Application for a non-material amendment following a grant of planning permission.
Town and Country Planning Act 1990

Modifications to the fenestration of the hotel reception areas and restaurant; addition of entrance plinth and disabled ramp to hotel reception; removal of an existing entrance lobby and bay window to the rear of the restaurant; addition of a glazed canopy and new restaurant lobby; conversion of first floor staff accommodation to additional restaurant area; addition of a roof terrace to the first floor and a fire escape; replacement of solid canopy at function room entrance with a glazed canopy; addition of a chimney to road elevation to restaurant; new pitched roof to existing gas cupboard on road elevation of restaurant.

Drawing Title:
PROPOSED
ELEVATIONS & SECTION
Drawing Number:
1516.PL05C

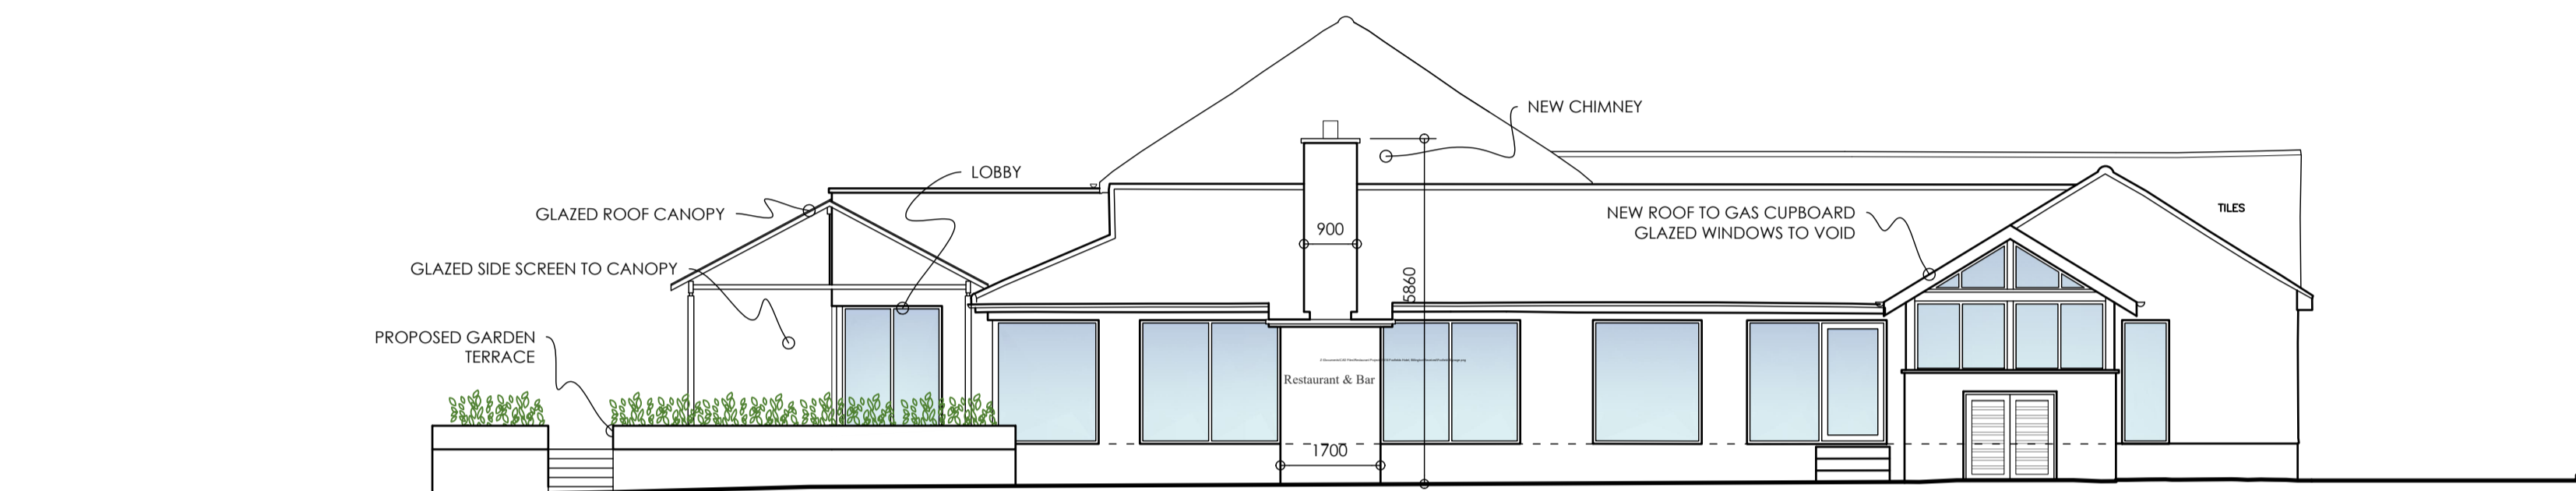
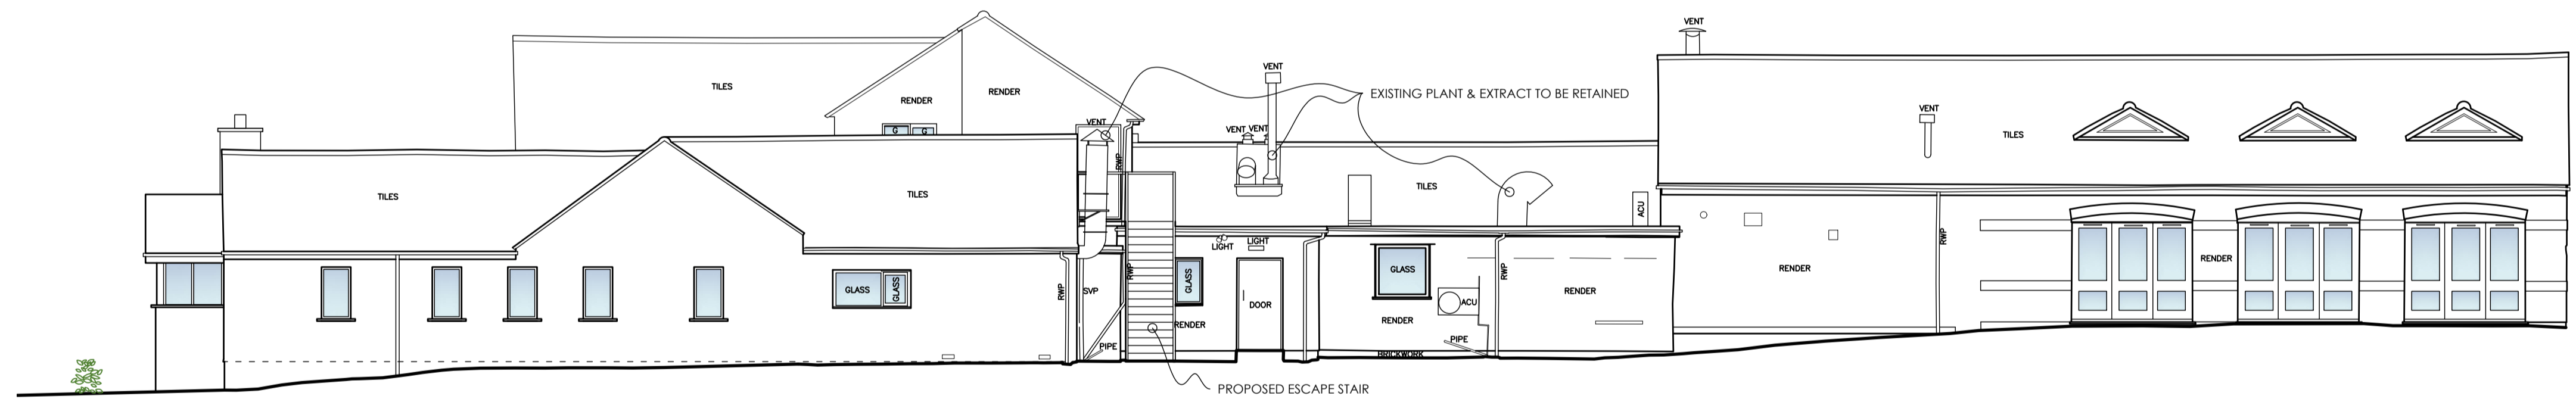
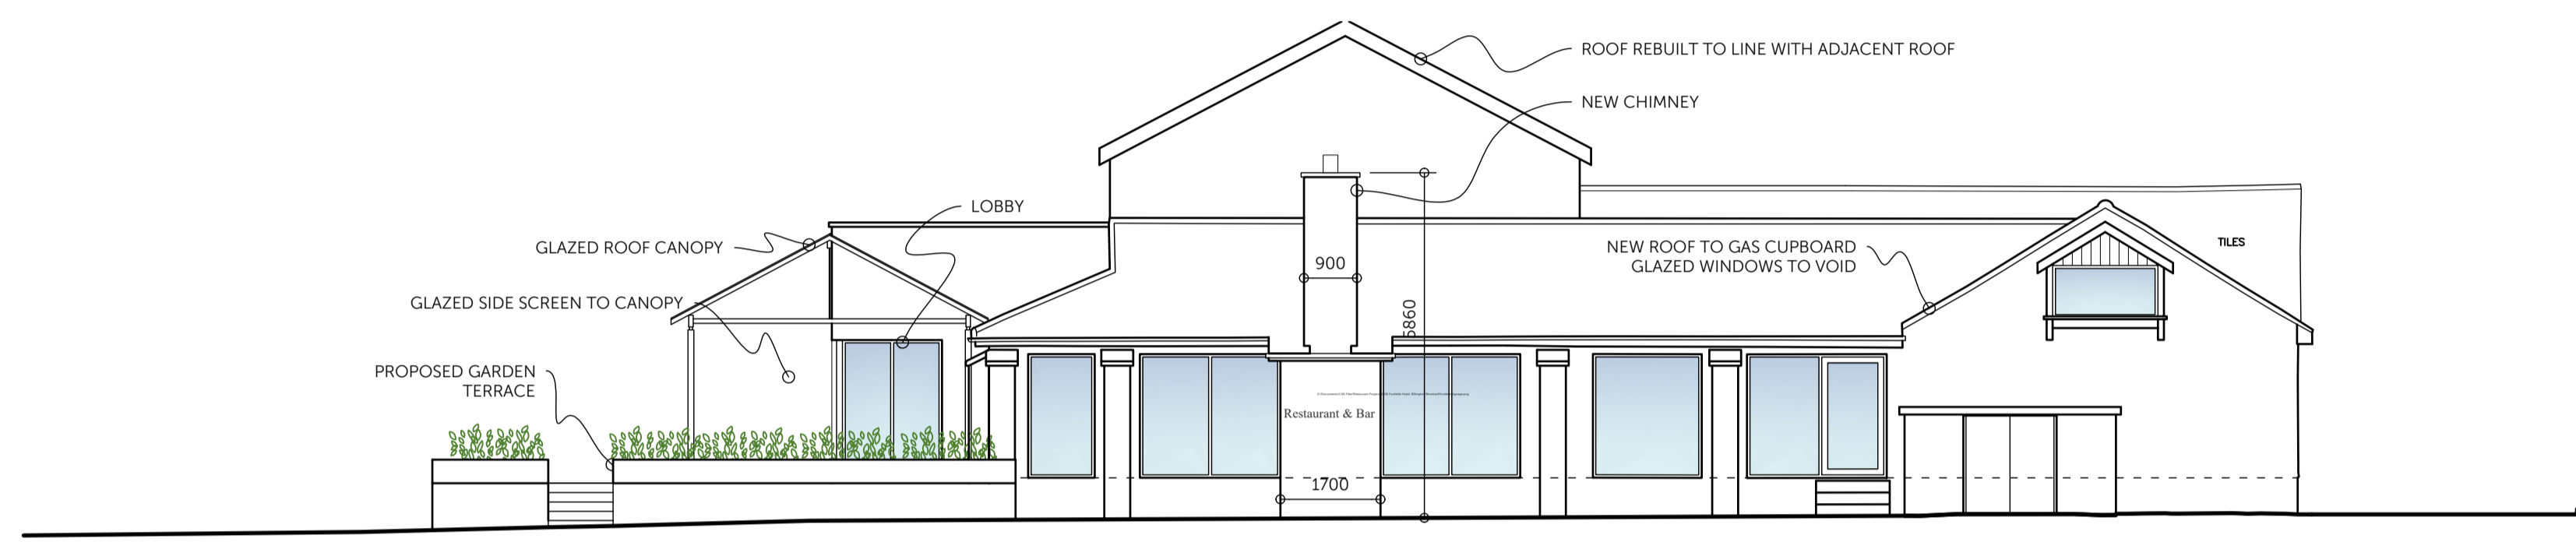
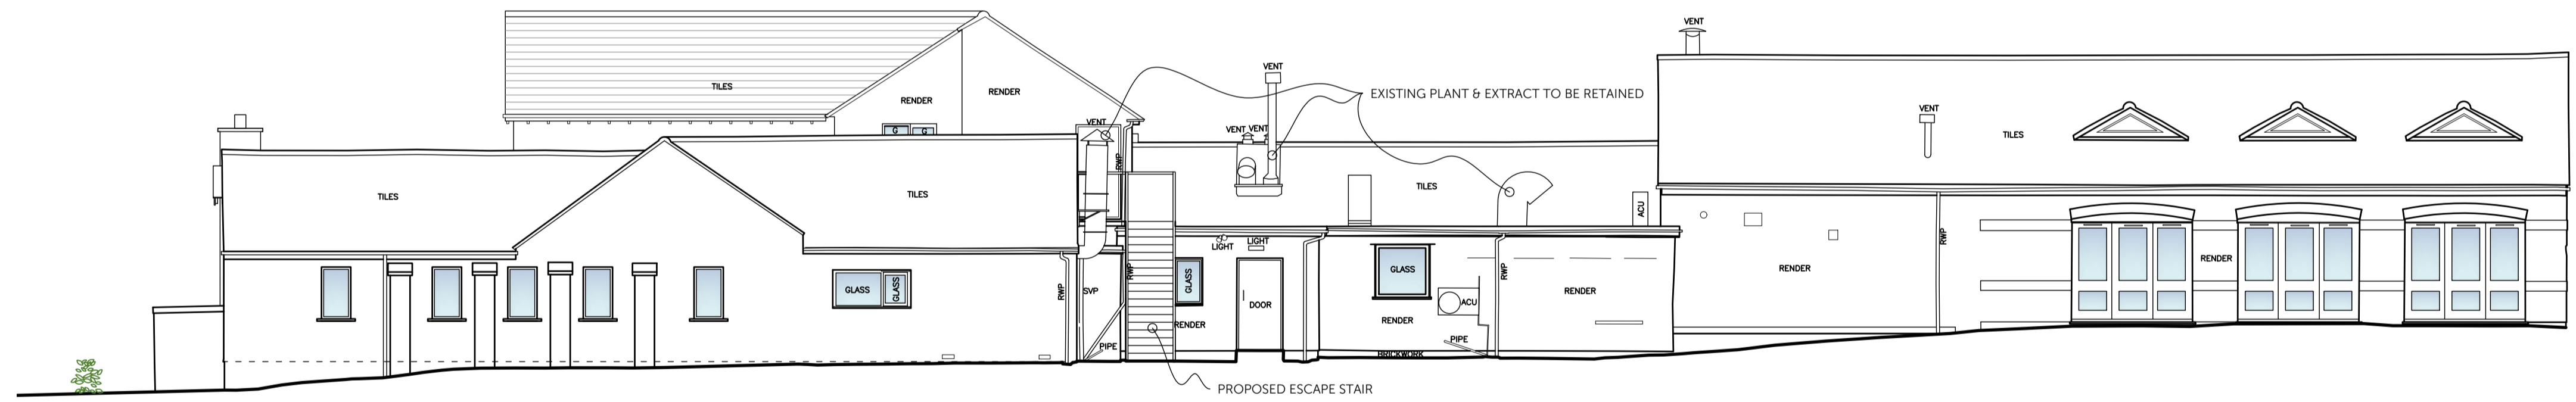
1. Roof to the existing two storey element of the restaurant:

It is proposed to raise the lower section of the two storey roof so that eaves and ridge level are the same height as the existing adjacent two storey element. Two windows have also added to the front wall, these do not provide views out as there is no first floor to this section of building as it is being removed.

It has become evident that part of the roof of the existing two storey element of the restaurant will need to be rebuilt as it is in a poor structural state, this is over the double height space at the front of the restaurant. Due to poor headroom in this area for the staircase from the ground floor and to the balcony, it is proposed to raise the eaves and ridge level to the same height as the existing adjacent two storey element. Two windows have been added to the front wall to allow more light into the centre of the restaurant, these do not provide views out as there is no first floor to this section of building as it is being removed.

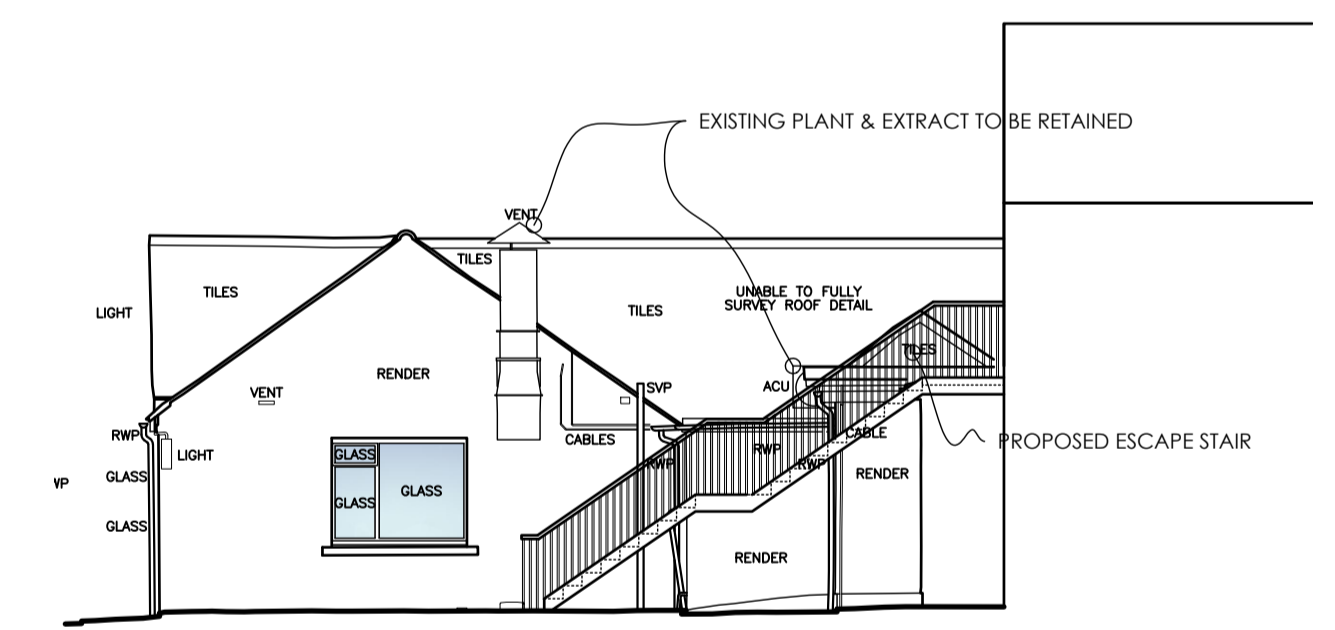
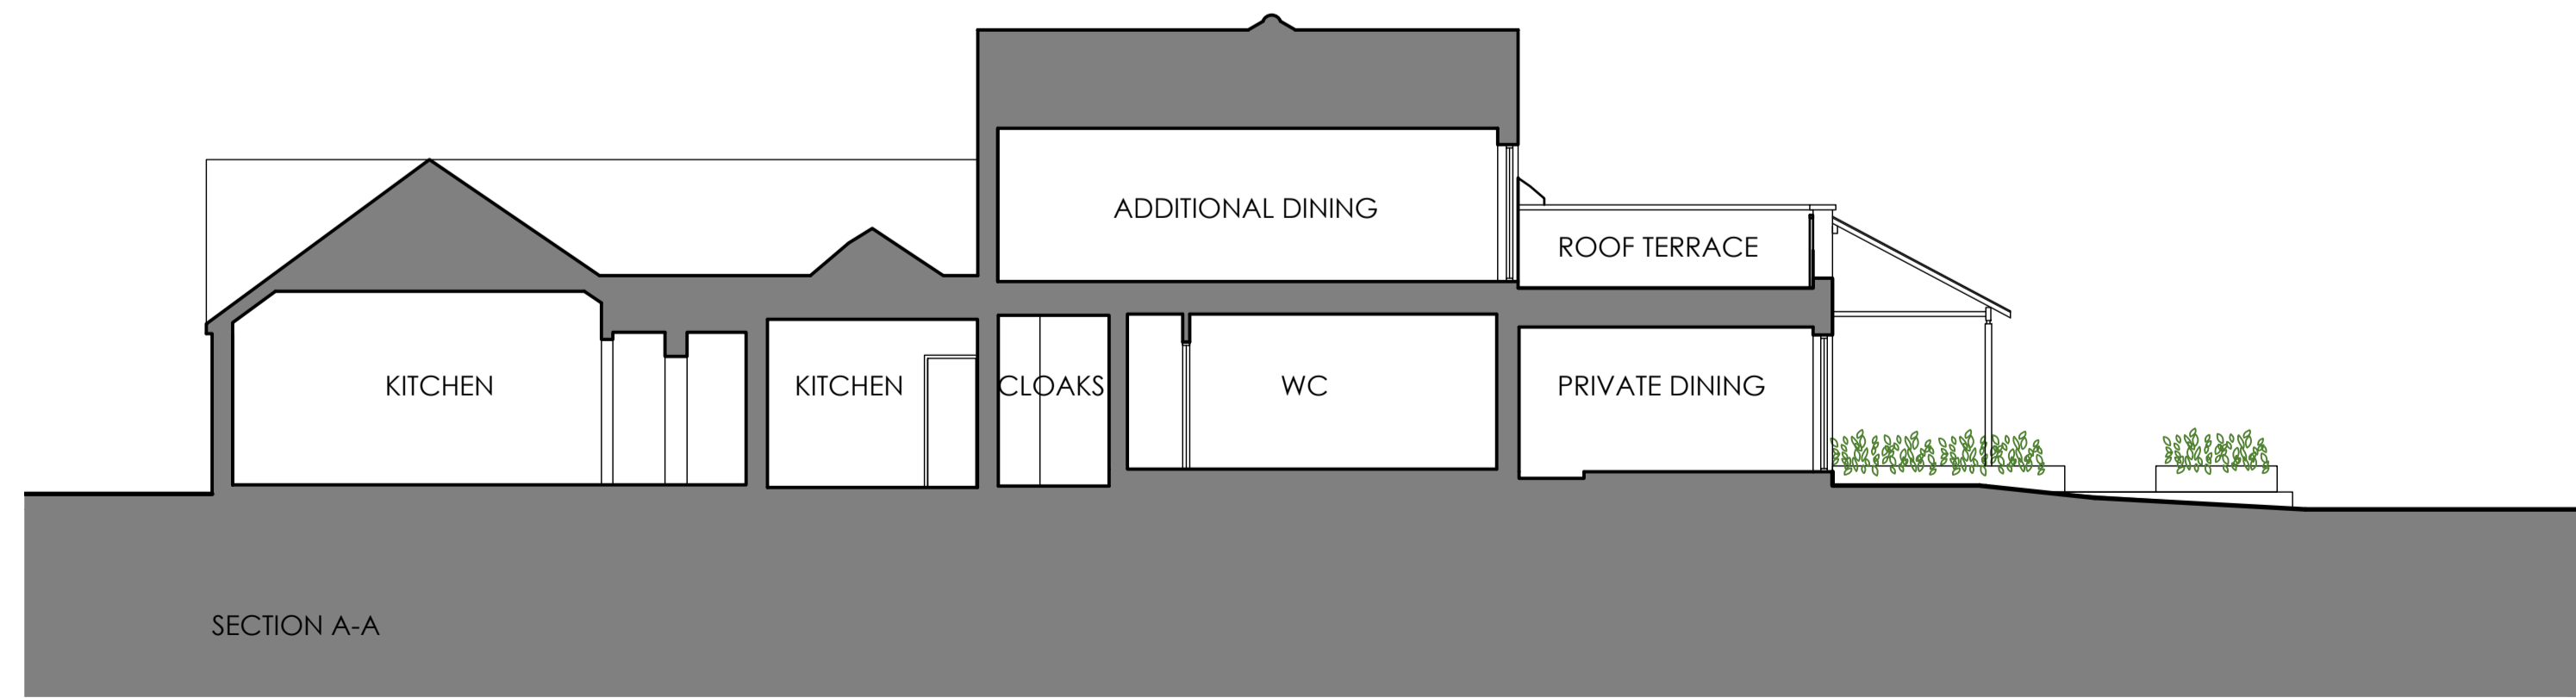
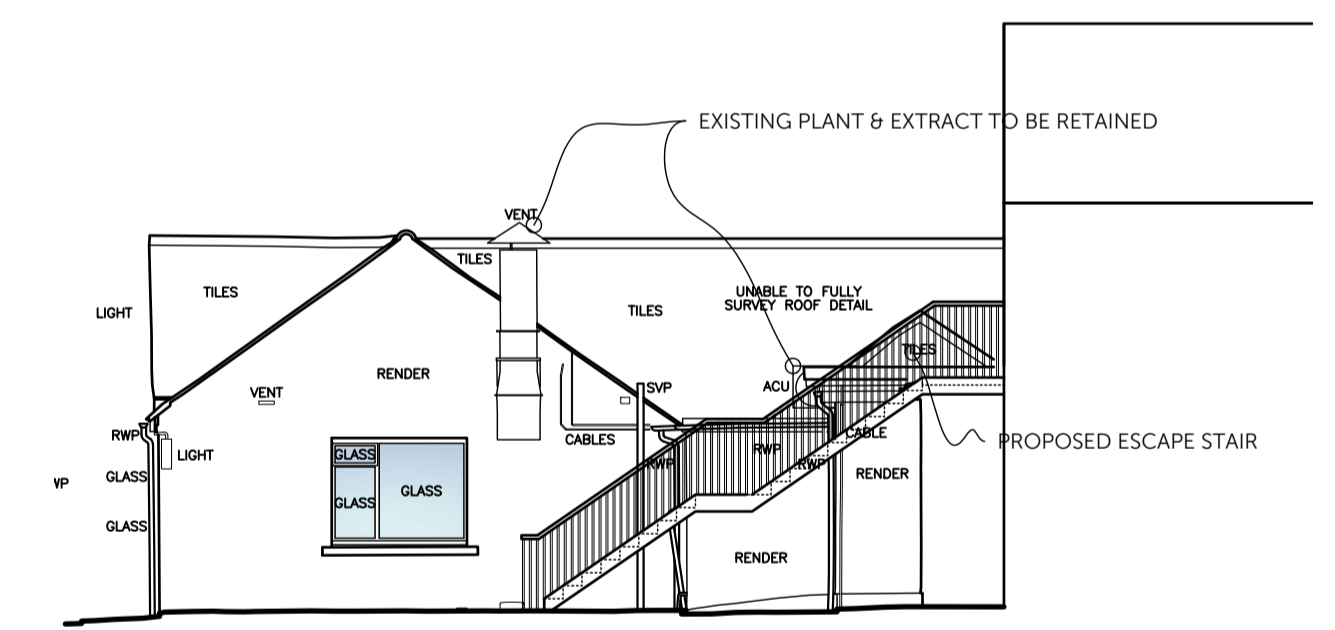
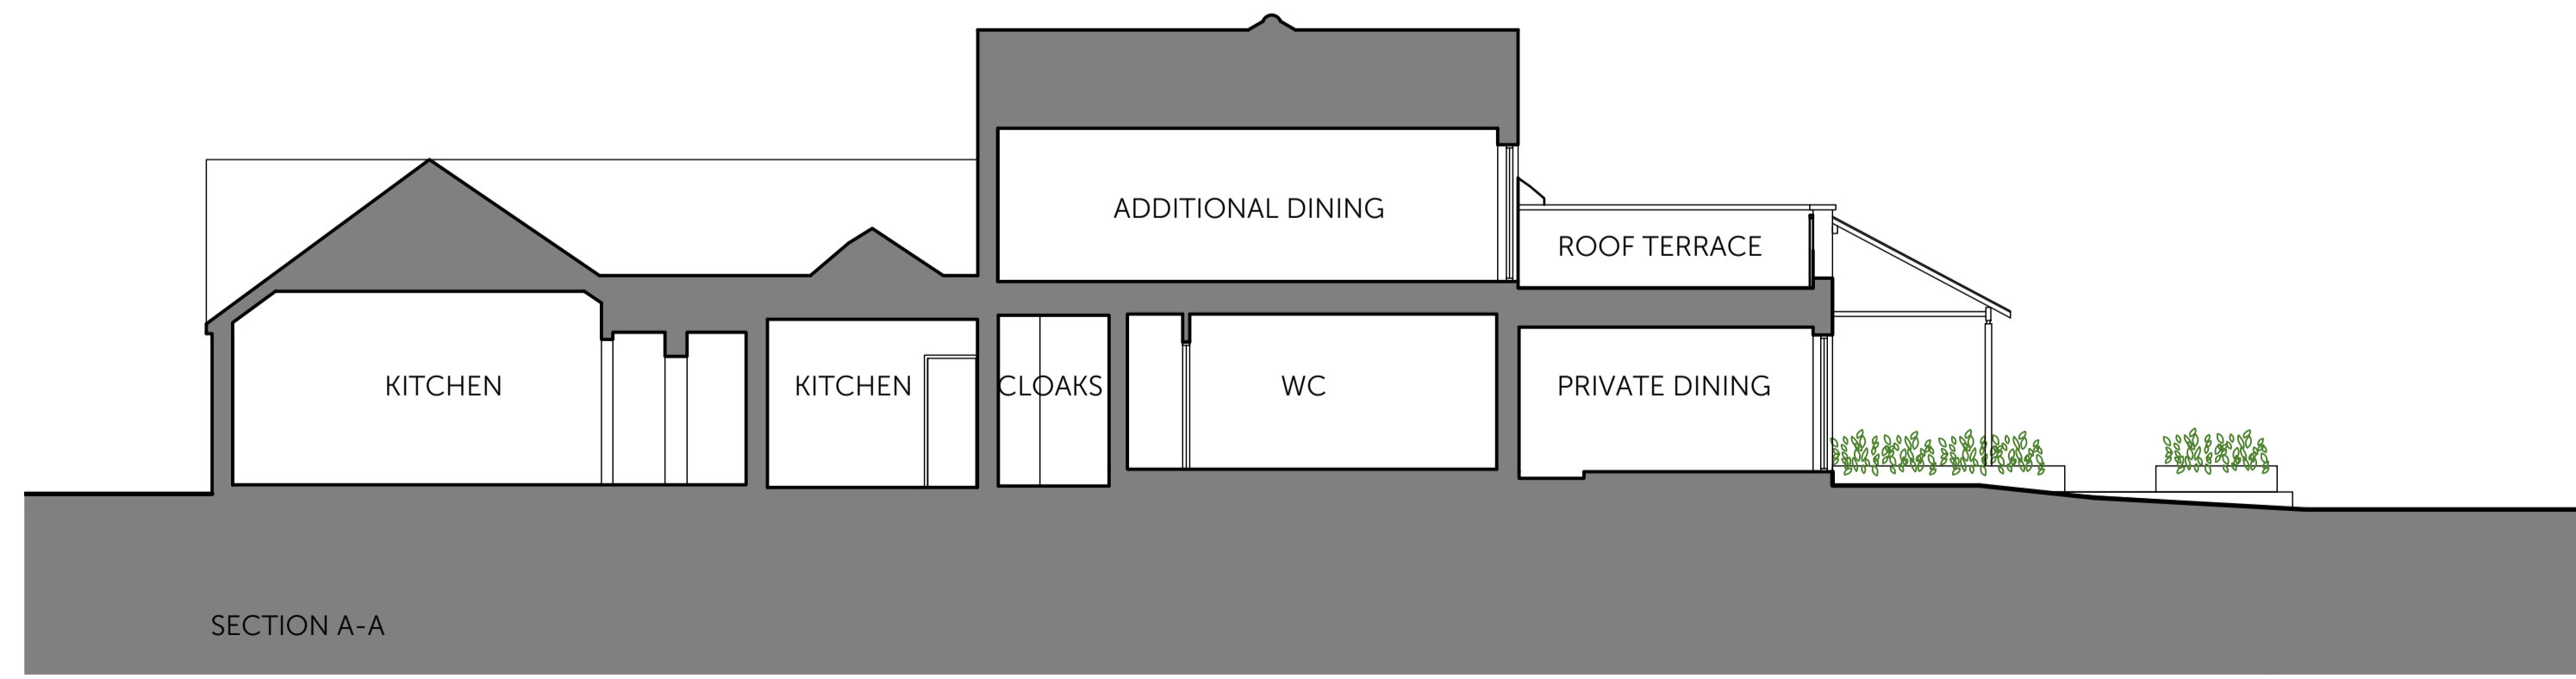
2. Structure above existing gas cupboard:

The approved glazed void above the gas cupboard will not be built, instead it is proposed to add a oriel window to the roof void to the top of the gable above the gas cupboard. This is a feature window only and will not be part of habitable space.

The approved glazed void above the gas cupboard will not be built as we are unable to alter this structure. Instead it is proposed to add a oriel window to the roof void to the top of the gable above the gas cupboard. This is a feature window only and will not be part of habitable space.
